Recommendation Report for Planning Permission

REF NO: P/93/14/PL

LOCATION: 1 Beach Road
Pagham

PROPOSAL: Part change of use of existing amusement arcade to manager's accommodation
(Resubmission following P/107/10)

PROPOSED MANAGERS ACCOMMODATION - GROUND FLOOR PLAN - 1:150

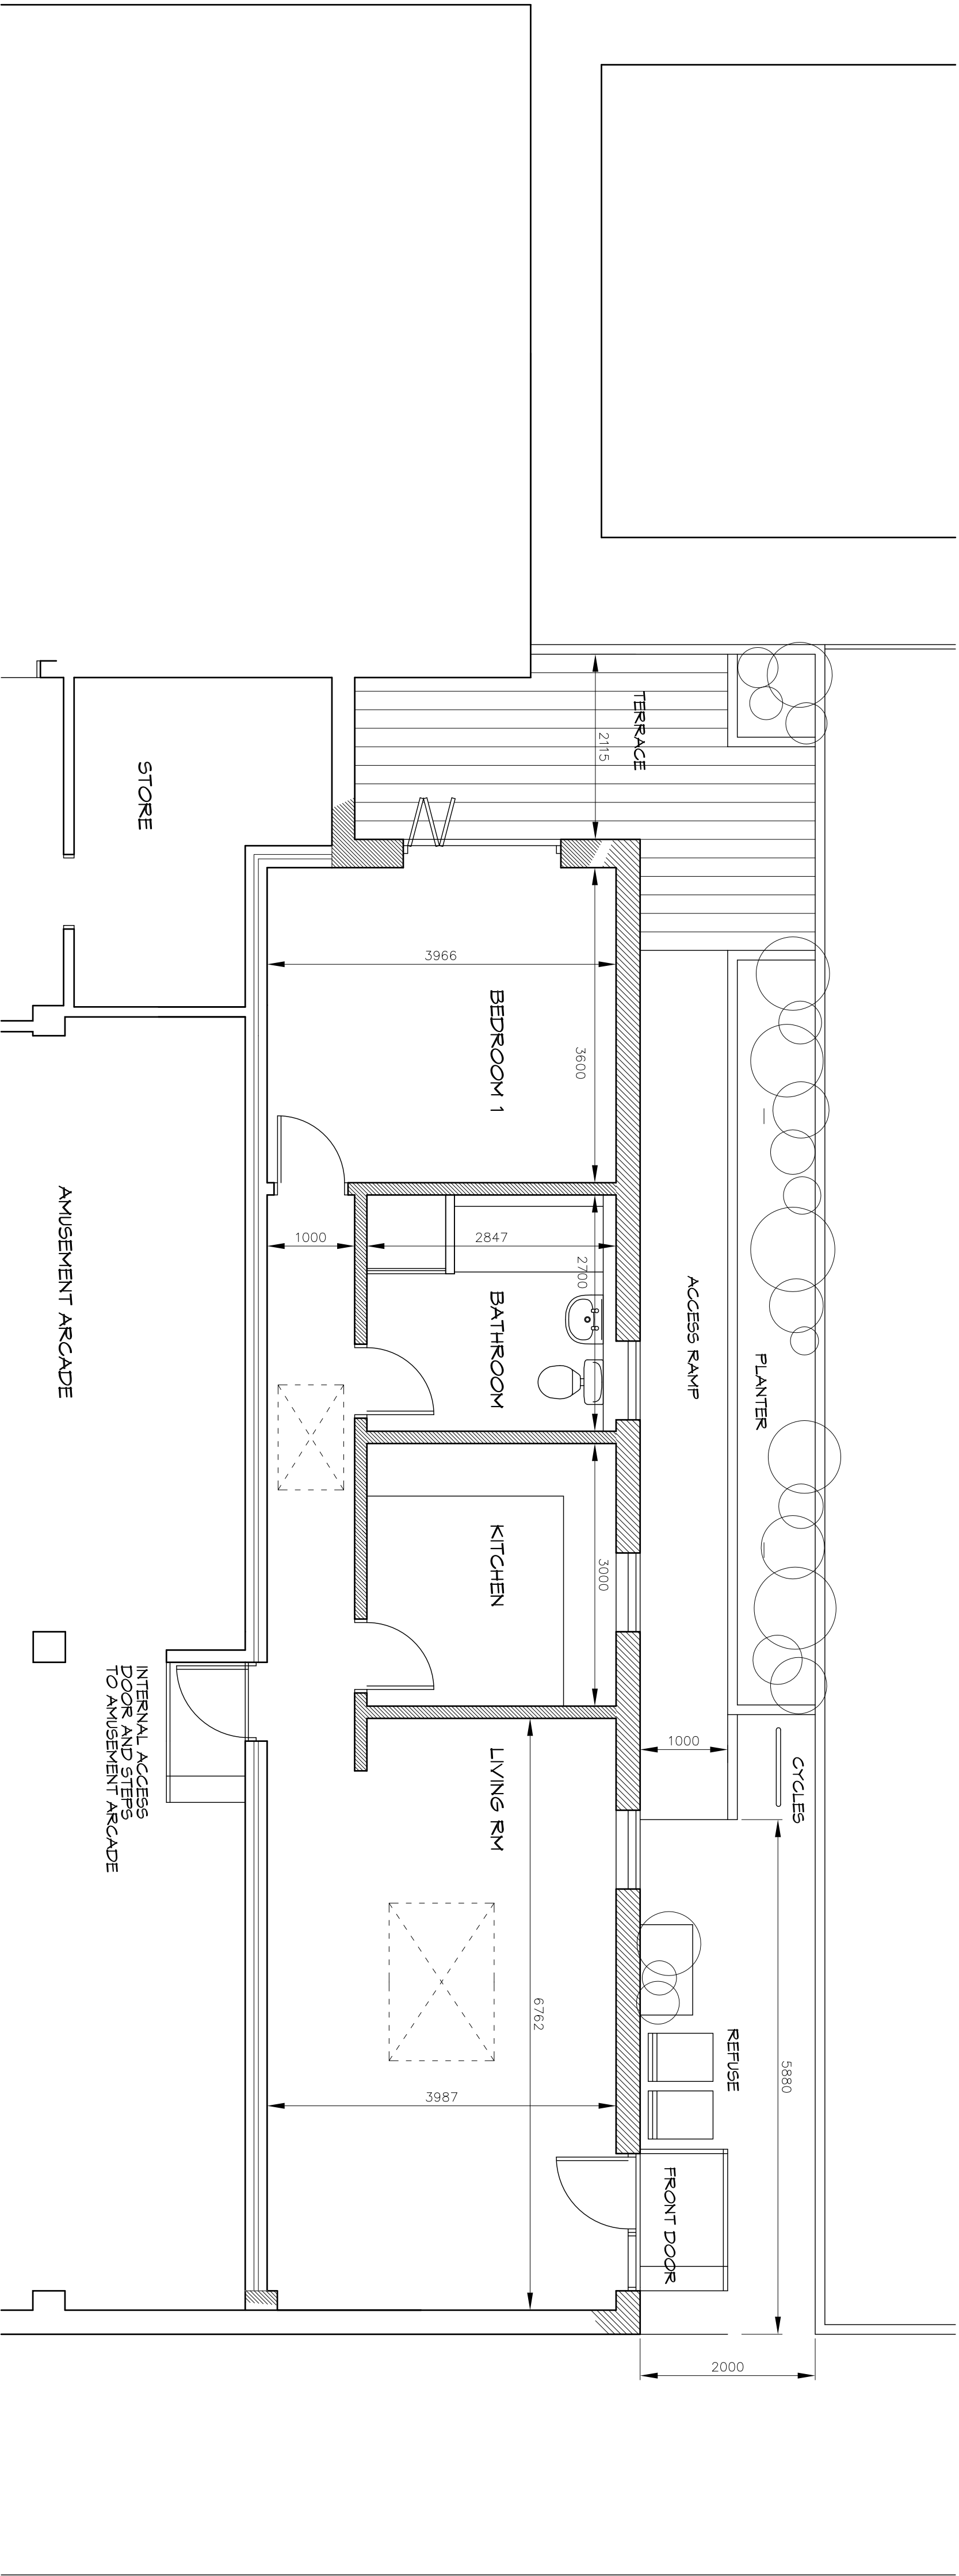
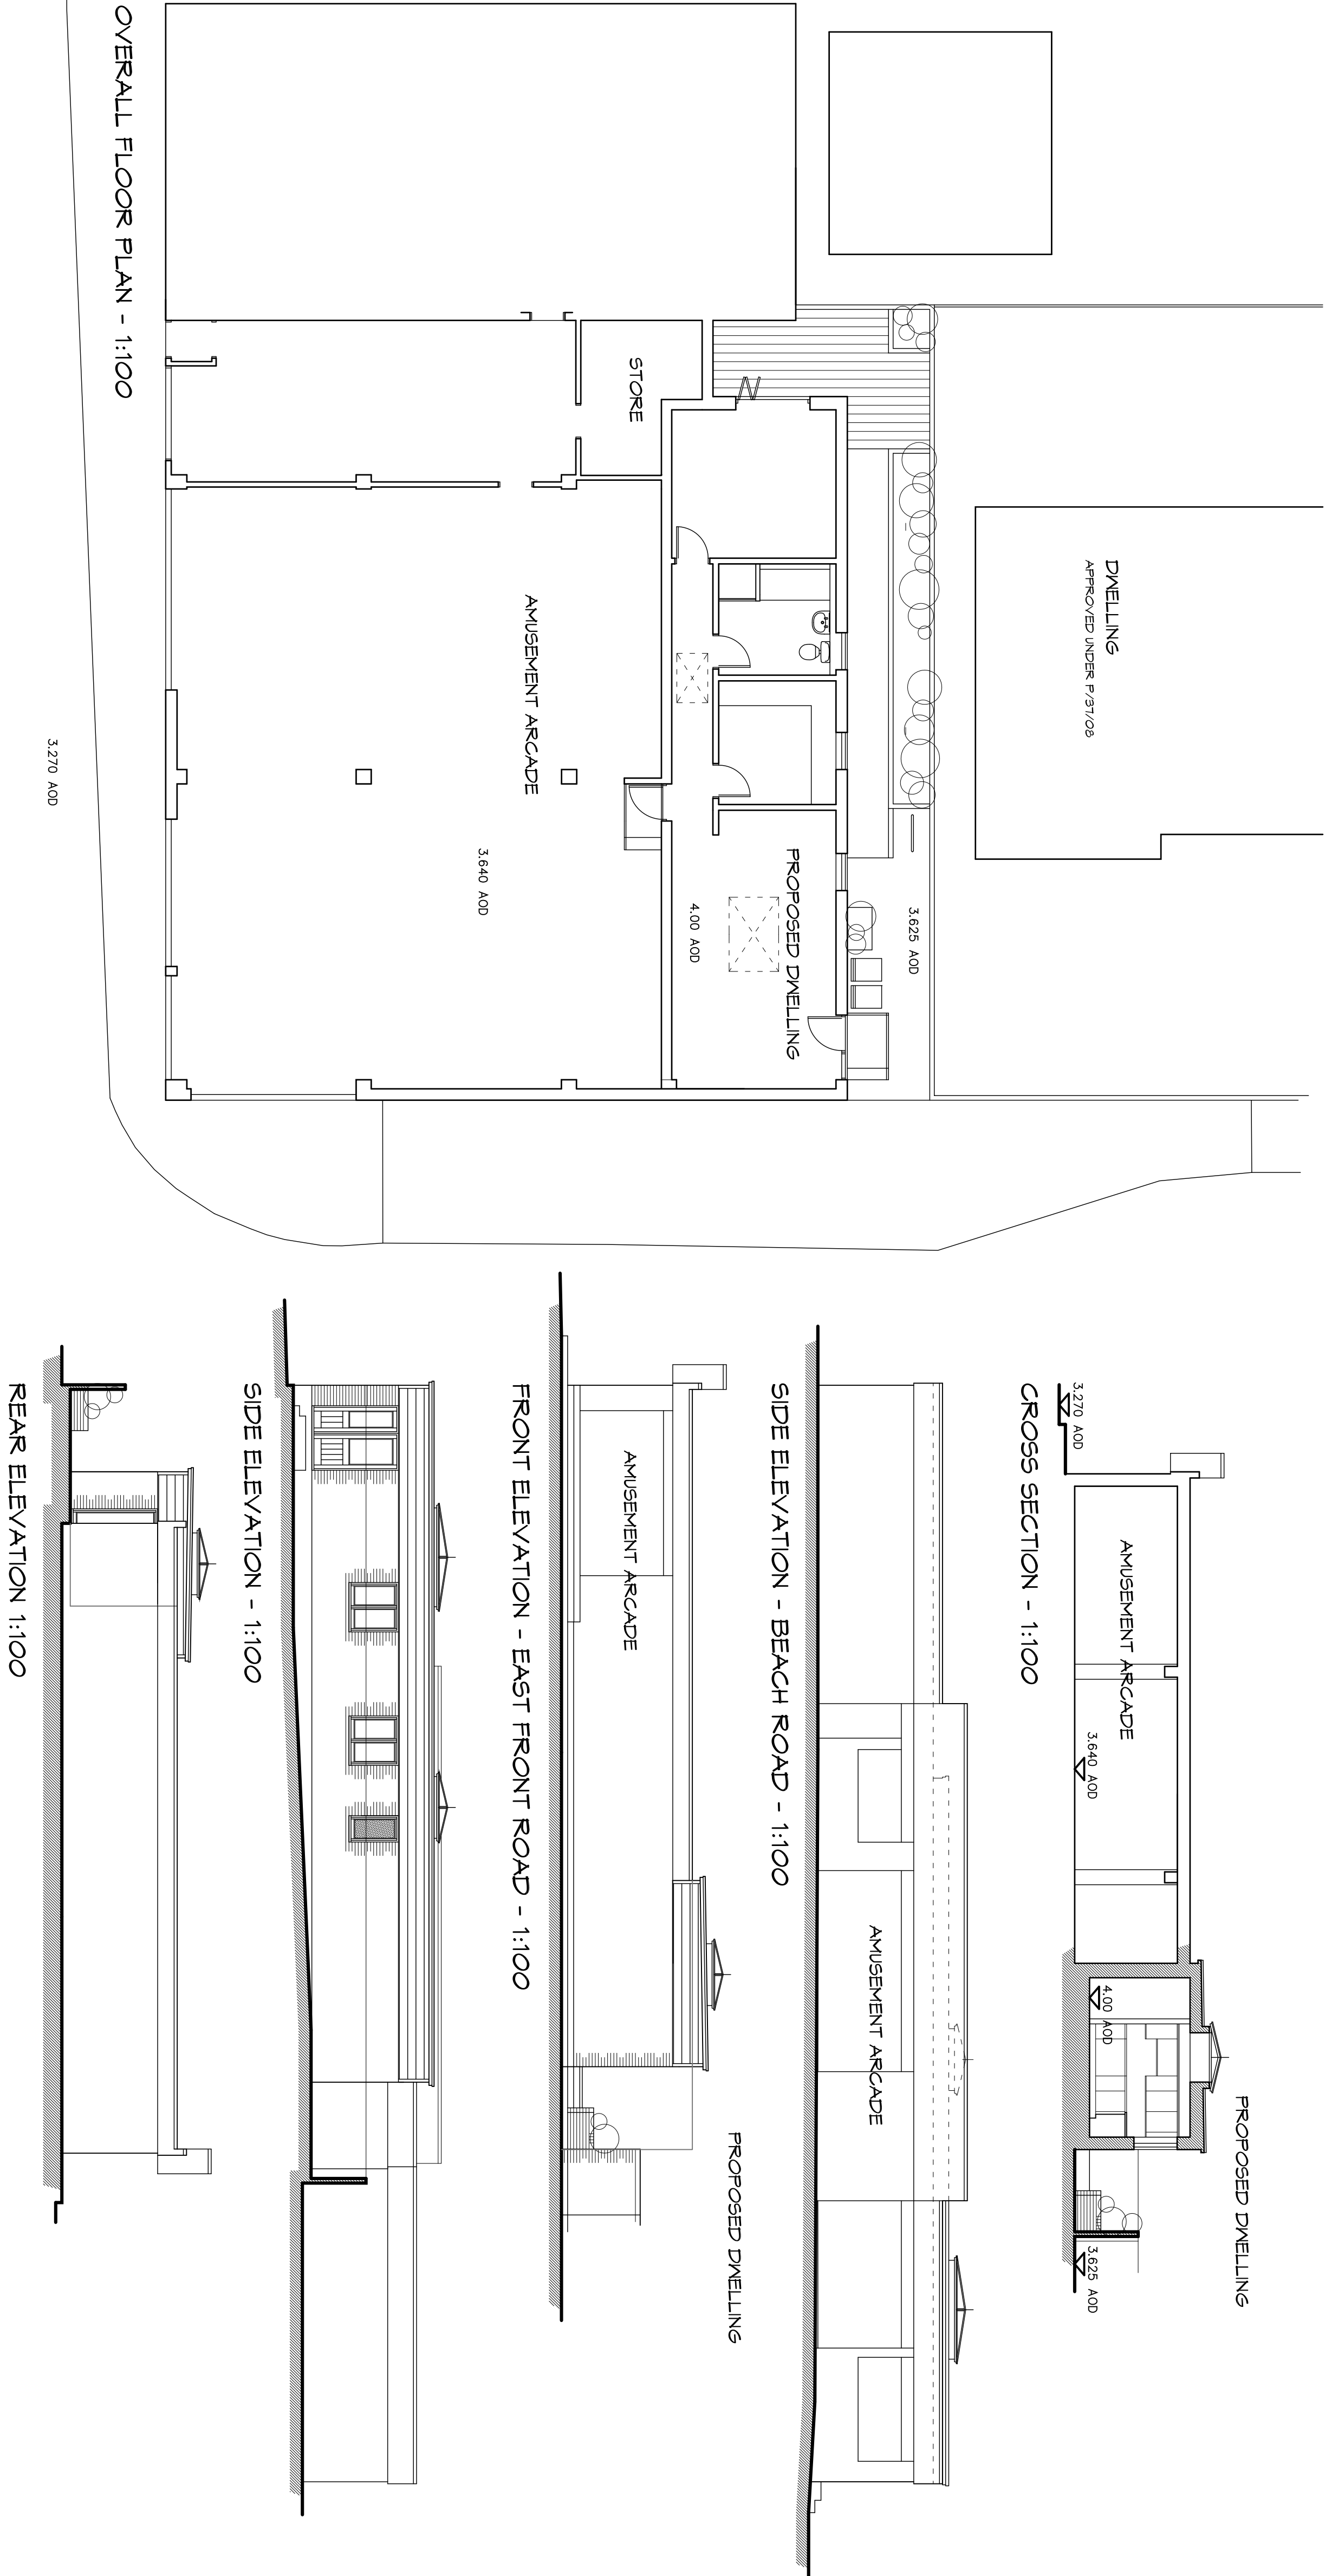
In terms of residential amenity there are windows proposed on the elevation facing the property constructed under P/37/08 which neighbour the application site on East Front Road. However, these are on the ground floor of a single storey elevation and with suitable fencing/screening along this section of the proposal (which will be conditioned), it should not result in undue harm to neighbouring residential amenity. With regards to the impact on prospective occupiers from noise emanating from the use of the amusement arcade this can be addressed by restricting the occupation of the dwelling for the manager (or staff) of the arcade who has been renting

The Flood Risk Assessment proposes that the floor levels for the proposed dwelling will be 4.0m above ordnance datum (AOD) (some 300mm above the current level) and slightly above the current level of the adjacent bungalow to the east. It also proposes to provide rear access so as to reach a safe haven on higher ground to the north of the proposed dwelling. Although the Environment Agency have not commented on this application, it is considered that their previous advice is still relevant and that therefore, whilst the site is on land prone to flooding, the mitigation measures proposed are sufficient to overcome the dangers posed.

* Given that the dwelling is attached to the existing amusement arcade, it is considered to be a flat rather than a bungalow. The requirement for 1 bedroom flats is only 4m² and the proposal includes amenity space (in the form of a private terrace) equating to 13.3m². The proposal therefore complies with this policy.

- 3 No development approved by this permission shall commence until plans that show floor levels raised to 4 metres AOD i.e. 300mm above existing ground level (as indicated in the agents FRA statement paragraph 2.2) have been submitted to and approved by the Local Planning Authority.

- 6 No development shall take place until details of screen walls and/or fences have been submitted to and approved by the Local Planning Authority and no dwellings shall be occupied until such screen walls and/or fences associated with them have been erected. The fence so approved shall be retained in perpetuity.
